DRB Application No.: 08DRB-70279 Project # 1006972  
Project Name: VALLEY VIEW ADDITION  
Agent: GARCIA / KRAEMER & ASSOC. Phone No.: 242-5566

**DRB CASE NO/PROJECT NO: 1006972**

DATE: July 8, 2008  
TO: Jack Cloud, DRB Chair  
FROM: Catalina Lehner, Senior Planner   
RE: Project #1006972, Highland Area Crematorium

RIVERSIDE FUNERAL HOME CREMATORY

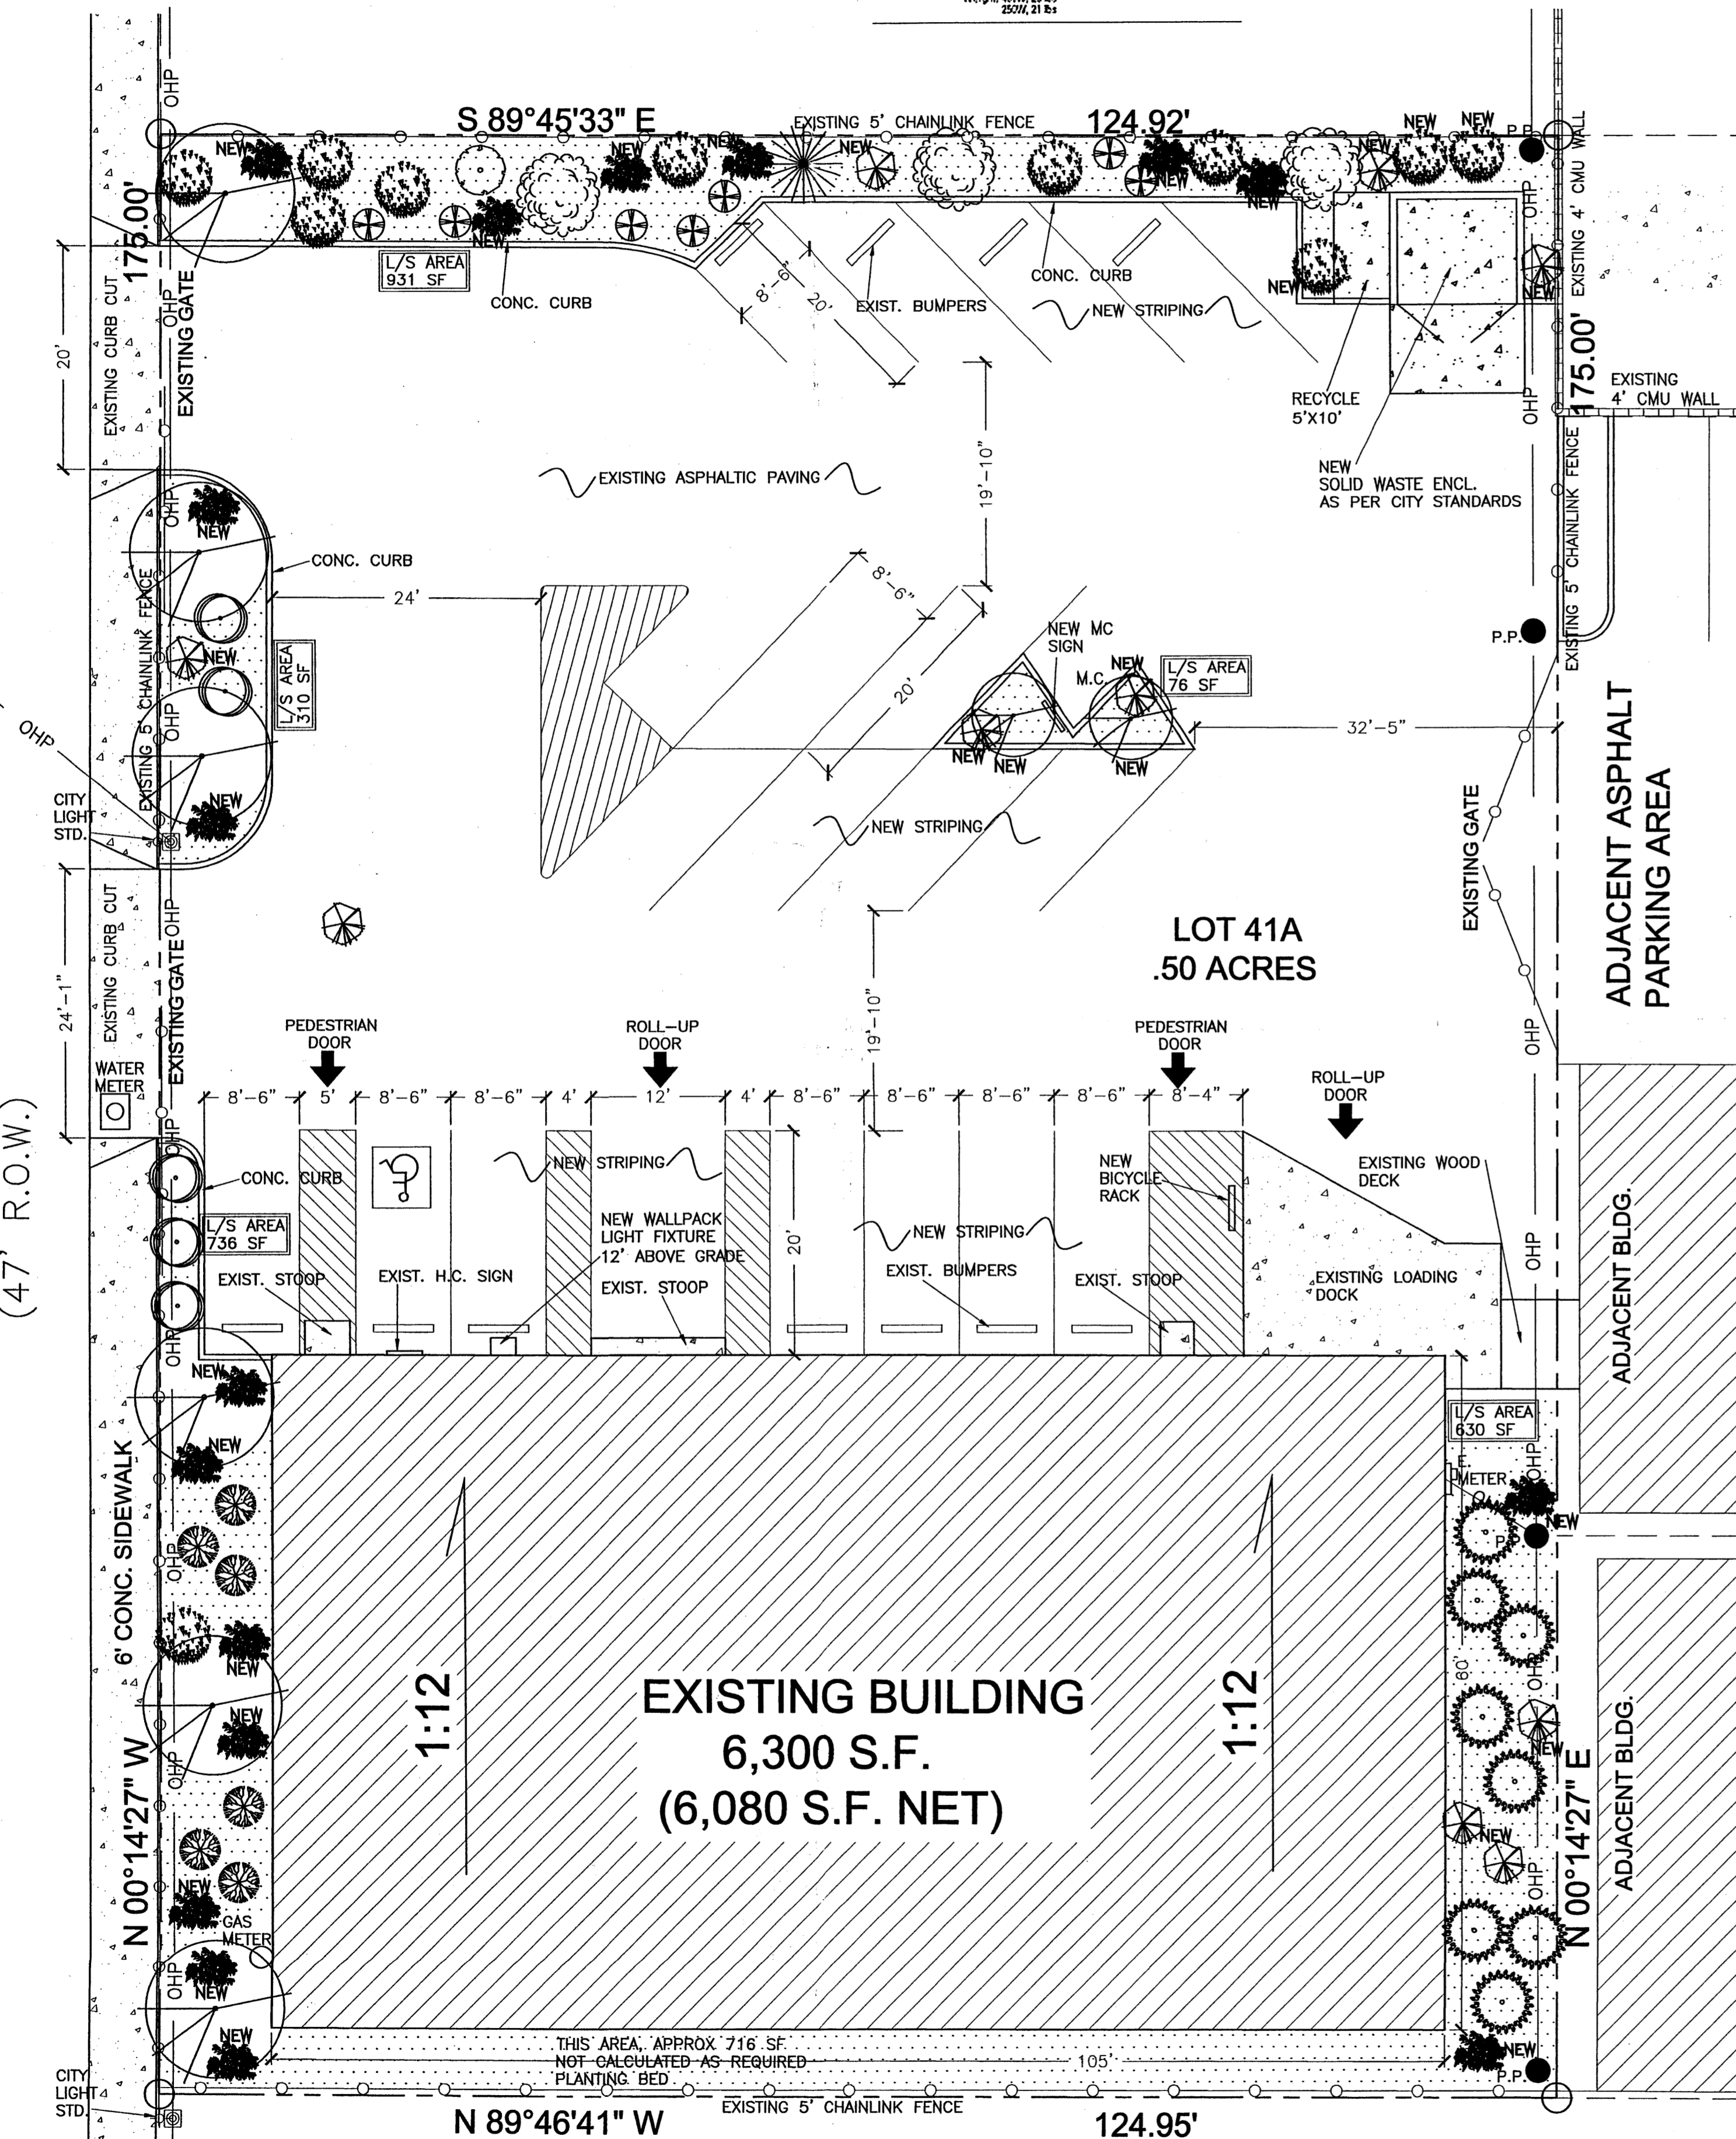
UTILITIES: verify fire hydrants

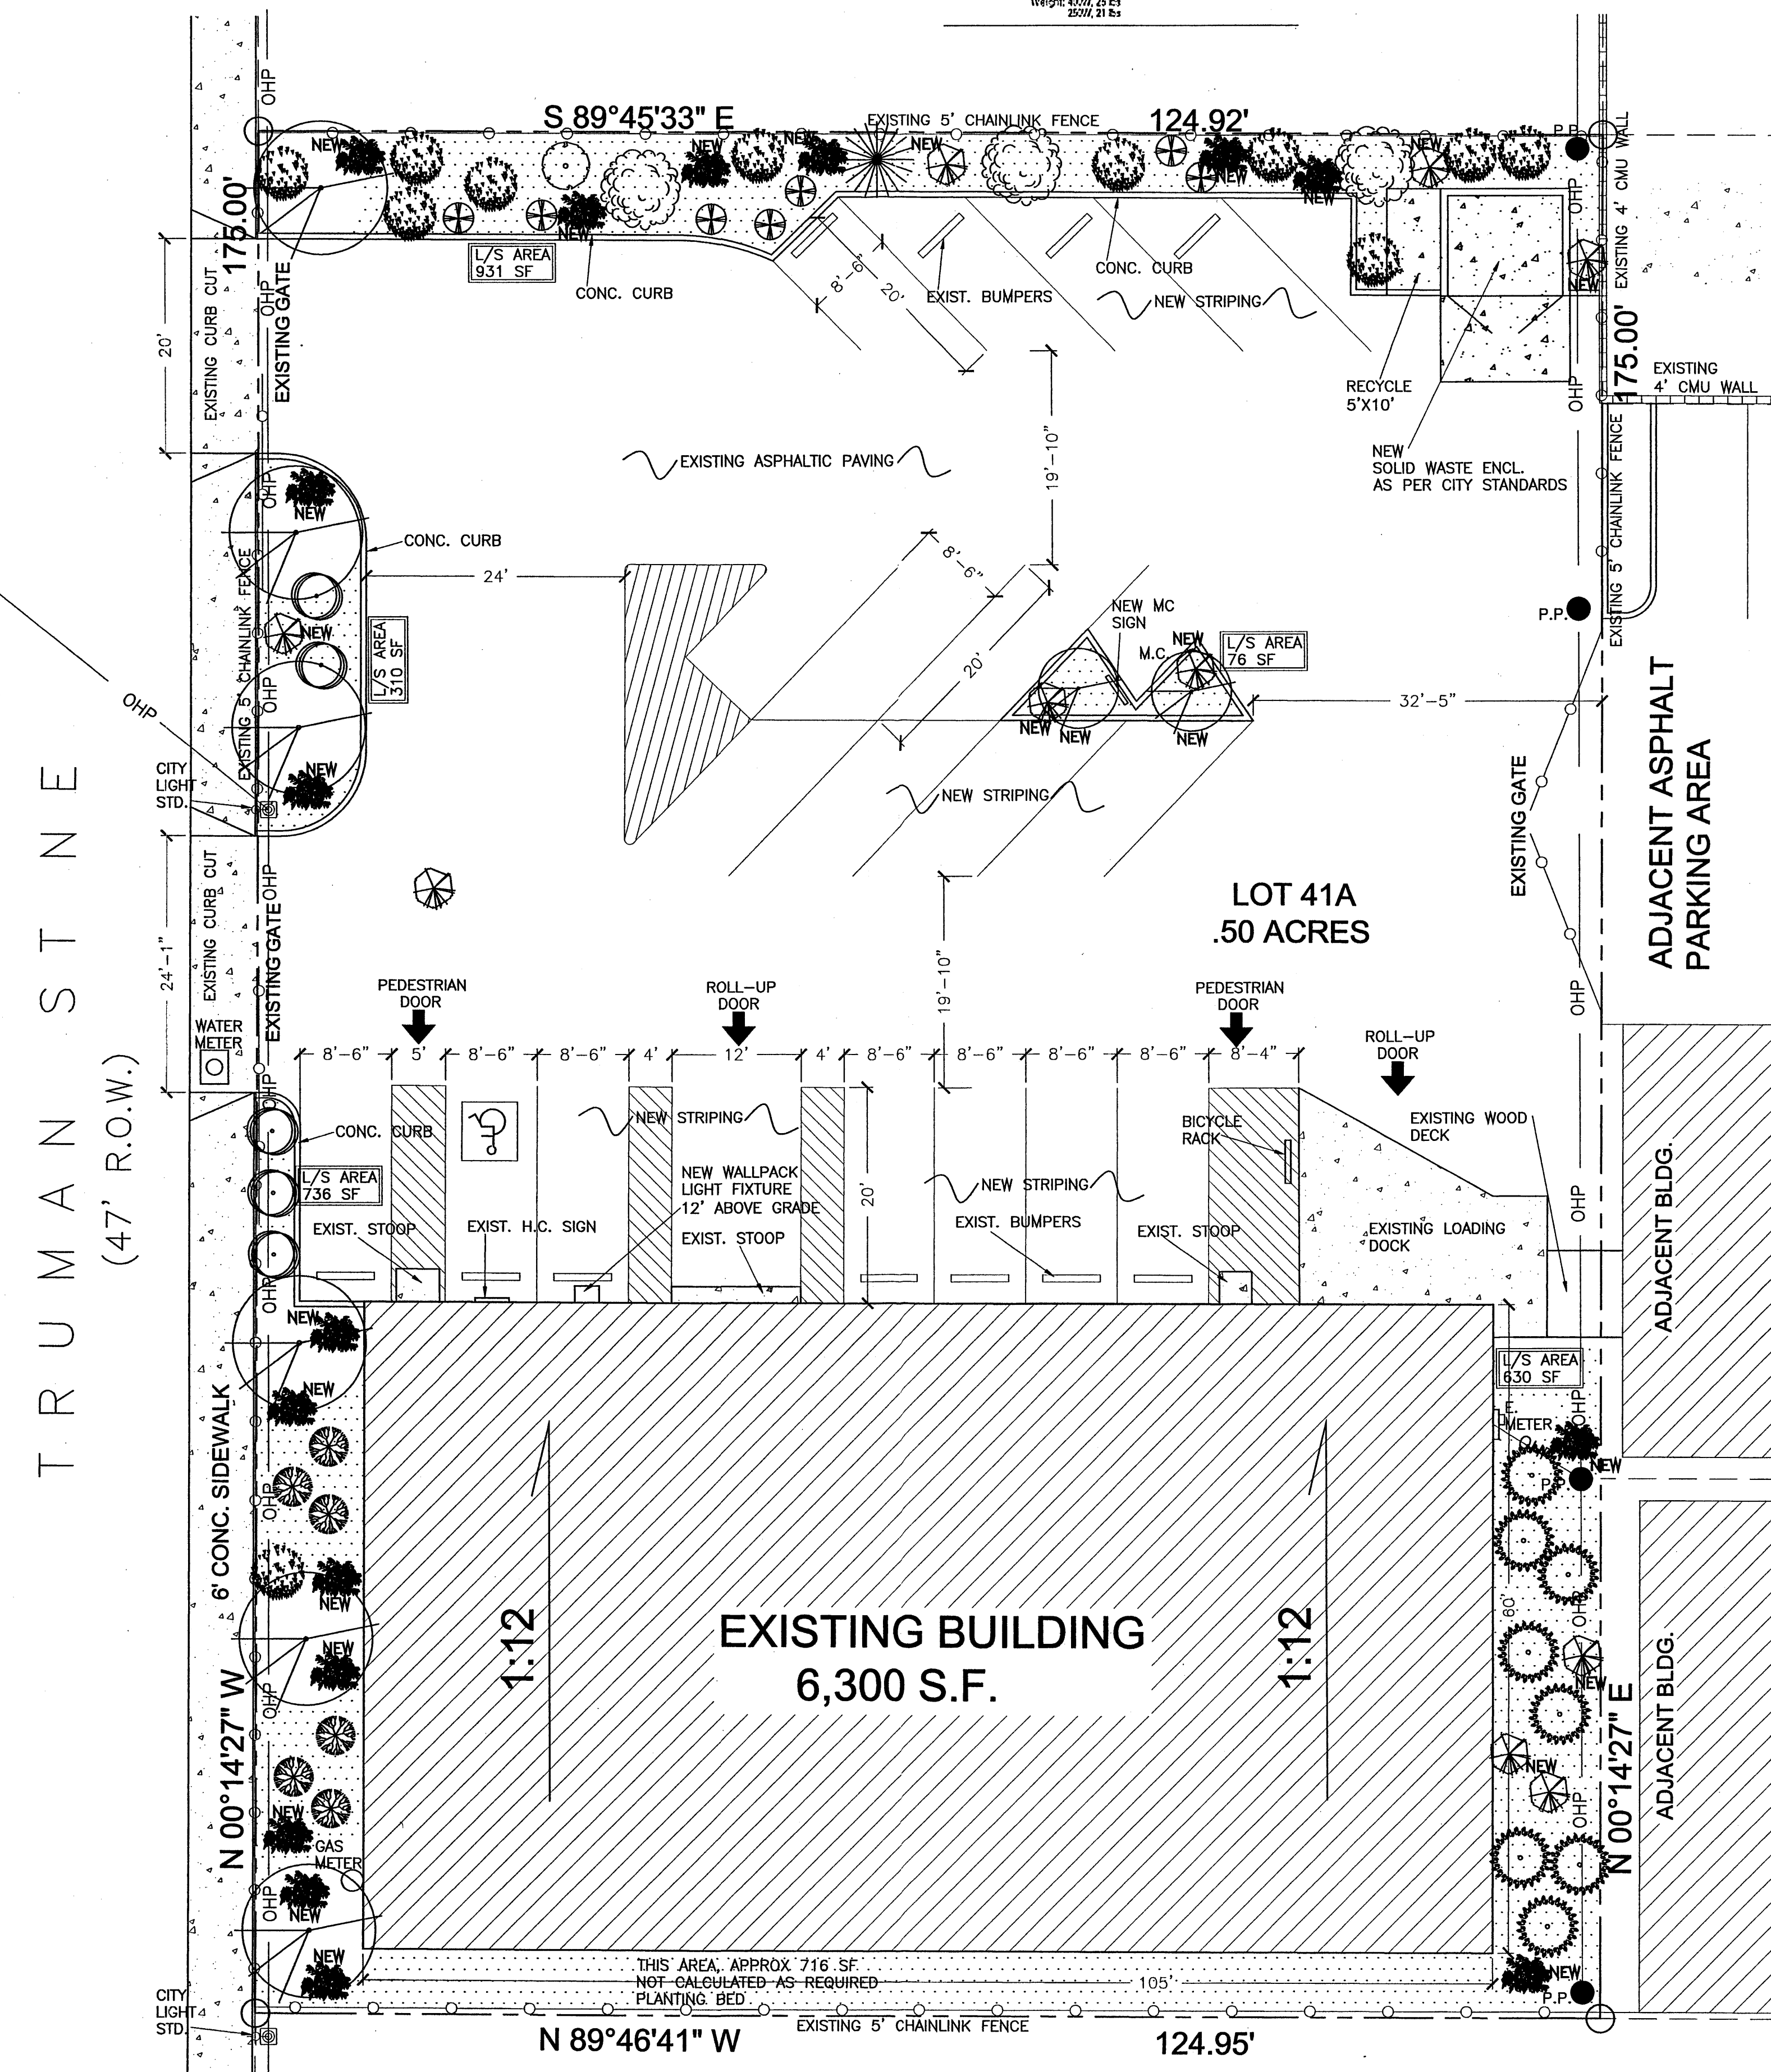
Planning Staff has reviewed the revised site development plan (April 8, 2008 version) and finds that the conditions are satisfactorily complied with. There is an inconsistency on the site development plan; the project data should match the numbers used in the landscaping calculations.

Issue: Planning Staff is confused about the statement in the applicant's June 3 letter regarding "the additional improvements that have been added to the site plan based on the two revisions made since the EPC hearing." Two rounds of revisions have occurred and were required to be made to incorporate the EPC's conditions of approval. Condition #7D refers to "trees", which can easily be interpreted to mean 2 trees as was discussed at the EPC hearing.
